## Matthew Rosel - Submission Details for John Shawcross (object)

Submission for Job: #5878 SSD 5878-2013 Sydney International Convention, Exhibition and Entertainment Centre Precinct - Mixed use Development in the Southern Haymarket Precinct (Concept Proposal)  
[https://majorprojects.affinitylive.com?action=view\\_job&id=5878](https://majorprojects.affinitylive.com?action=view_job&id=5878)

# The inconvenient truth

Figure 5.3. Building heights site diagram

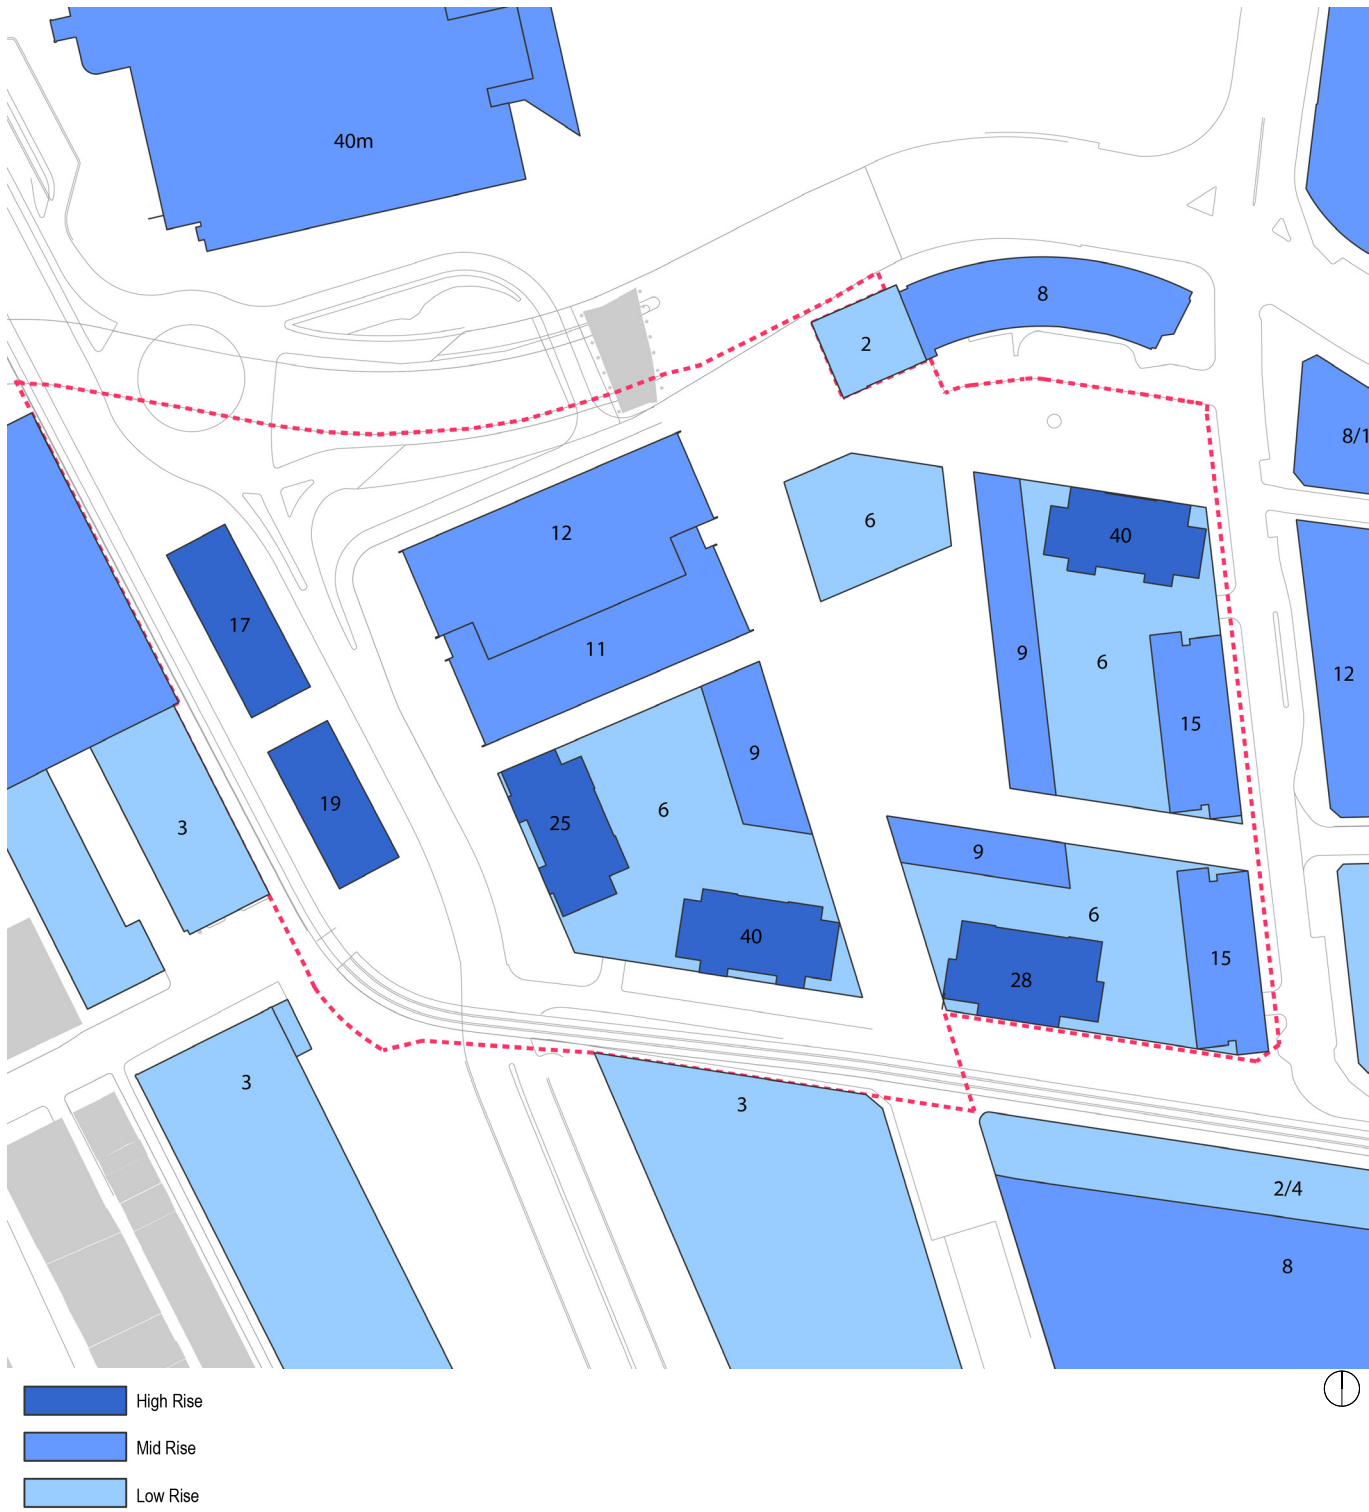
Once again, it is hard to understand how the placement of a 100 metre high block (SE1) some 30 metres away and the 140 metre tower (SW3) 60 metres away can fail to affect the interpretation of the Market City façade. Similarly, the 140 m high (NE3) tower dominates the heritage pumphouse about 30 metres away.

A southerly wind being channelled between SE1 and SW3 will howl up the boulevard and will probably cause a cyclonic effect in the Haymarket Square.

DEVELOPMENT APPLICATION  
 VIEW IMPACT ANALYSIS  
 PEAK TOWER - LOW LEVEL - WEST  
 RL 46.922

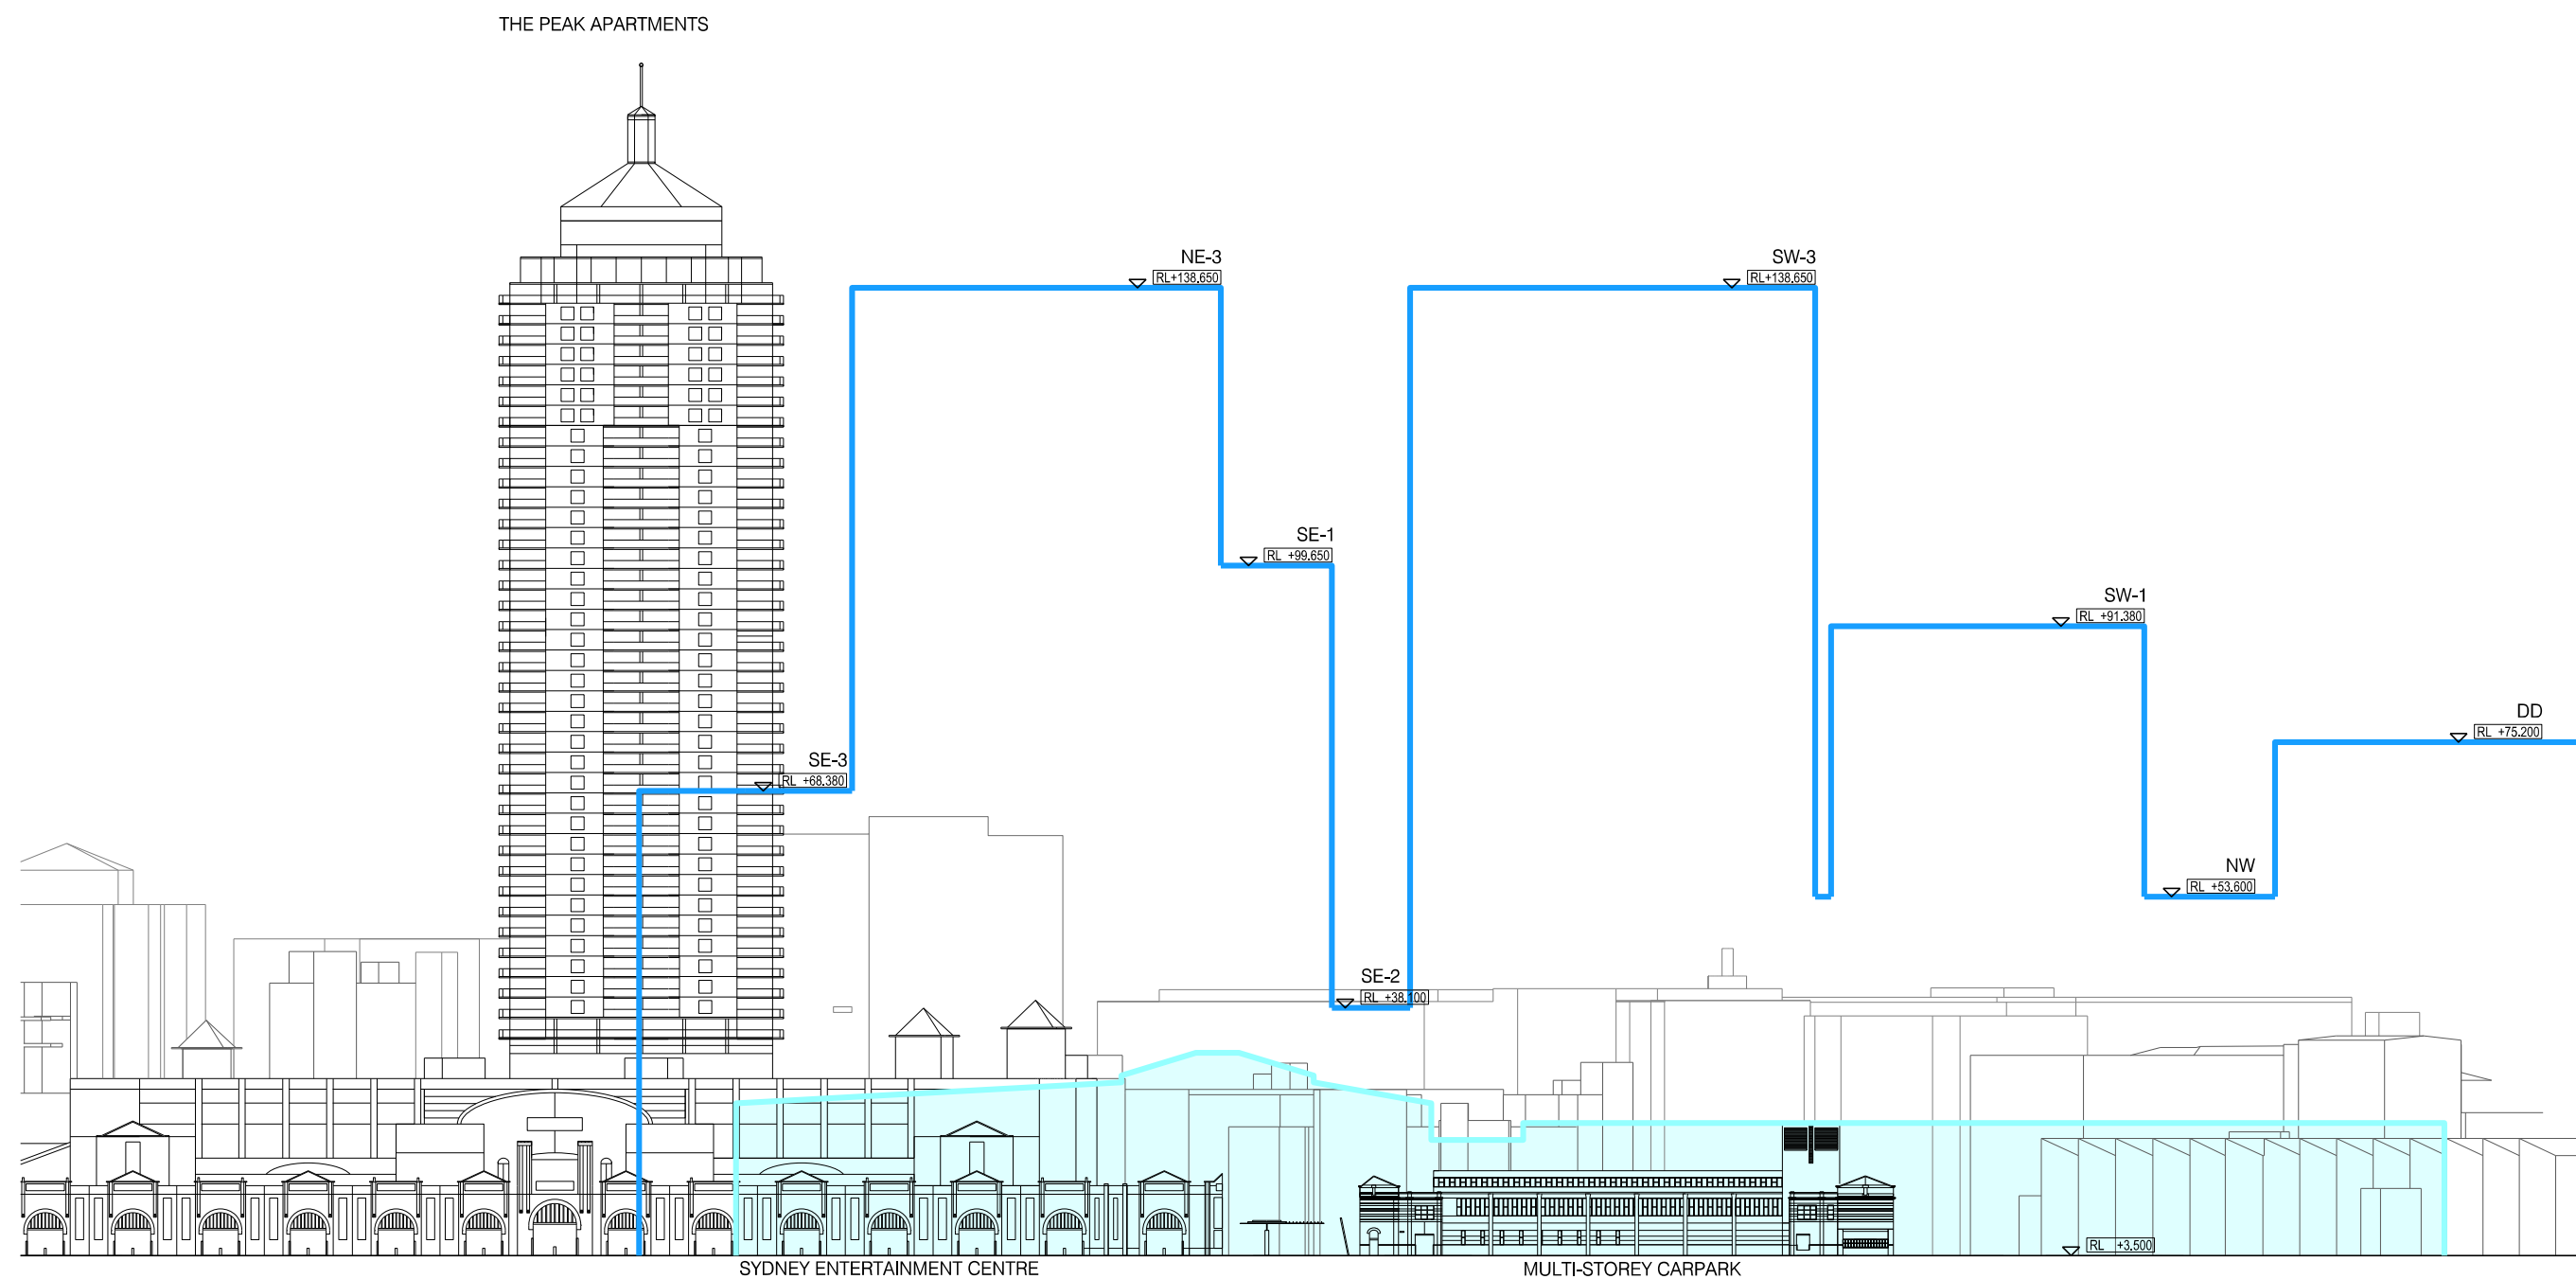
The following figure – buried in SSD 5755 illustrates the size of the proposal in relation to The Peak.

I presume to hide the inconvenient truth.
